Planning Application Ref: AW/19/20/T

Location: 6 Cedar Close, Aldwick, PO21 3BE

Description of works: Reduce overhang on neighbouring 1no. horse chestnut to 1m, reduce overhang on 1no. oak tree to 9m and reduce height to 6m and laterals to 4m on 1no. ash tree

REF1

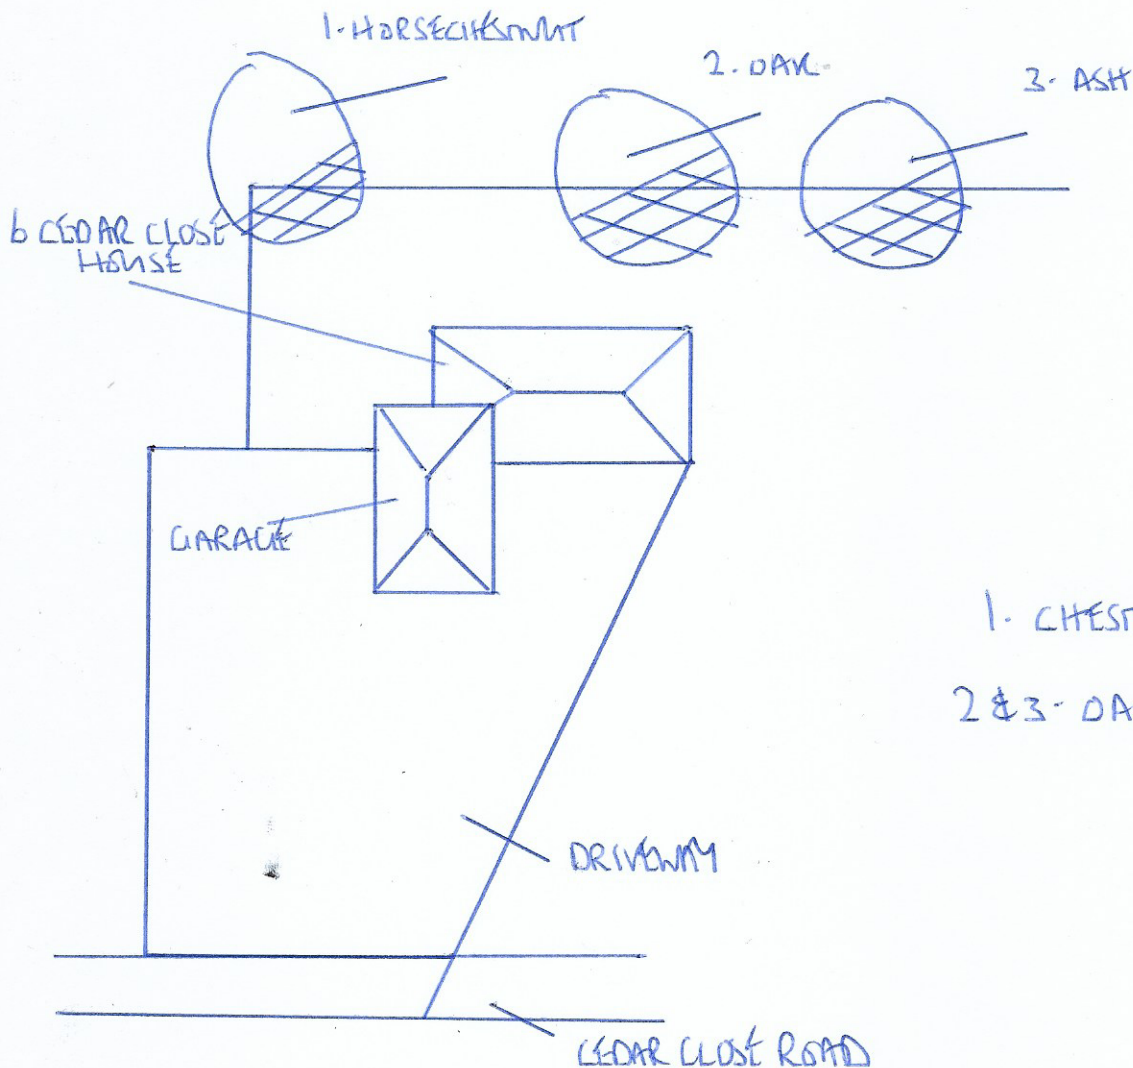
- **T1** - Appears to be in a fair physiological state. It is twin stemmed from near its base and supports a full and unmodified upper crown, so presents an attractive profile both to surrounding residential properties and users of public highway (footway and carriageway). As such, it has high amenity value.

- There have been multiple low branch removals historically and more recently a split large limb from mid-crown.
- The applicant seeks to reduce the extent of crown spread by 2m to leave 9m, although pruning need only apply to the northern (subordinate) stem, to meet their objective.

- **T2** - Large ornamental tree which outwardly and from a distance appears to be in a fine physiological state. It has a full and spreading crown, visually impressive from surrounding residential properties and in part to users of the public highway (footway and carriageway). As such, it has high amenity value.

- The applicant seeks to address concern over the apparent weak condition of an already truncated subsidiary stem (diameter of approx. 350mm at its departure from the main stem), with resultant dense and developing limb/branch framework over garden. There is evidence of a major limb tear-out in the past. The proposed work specification could apply to all crown overhang on this aspect.

- The intent behind proposals for T1 and T2 is acceptable, although greater clarity is required with the specification to ensure no loss of visual amenity were that to be executed to its full extent. These are high profile specimen trees of significant public and visual amenity and must be carefully pruned to maintain reasonable enjoyment of residential property and with respect for natural tree form.
- T1 and T2 are significant features in the local landscape and appear to be in adequately sound and healthy condition. The tree surgery proposed in the application could result in excessive reduction of the trees landscape impact and undue detriment to the visual amenities of the locality.

- As it stands, I recommend **REFUSAL** for this application.

- I would like to see the applicant submit a revised work specification such as detailed below, which would seem to address their concerns whilst preventing a diminution of the trees landscape and public amenity value:

T1 Oak (applies to subordinate stem, northernmost of twins)

- Reduce lateral extent tending east by no more than 2metres, leaving a minimum of 9metres spread from stem base.

T2 Horse chestnut (applies to truncated subsidiary stem with diameter of approx. 350mm at its departure from the main stem)

- Reduce lateral extent tending east by no more than 7metres, leaving a minimum of 1metre overhanging into garden.
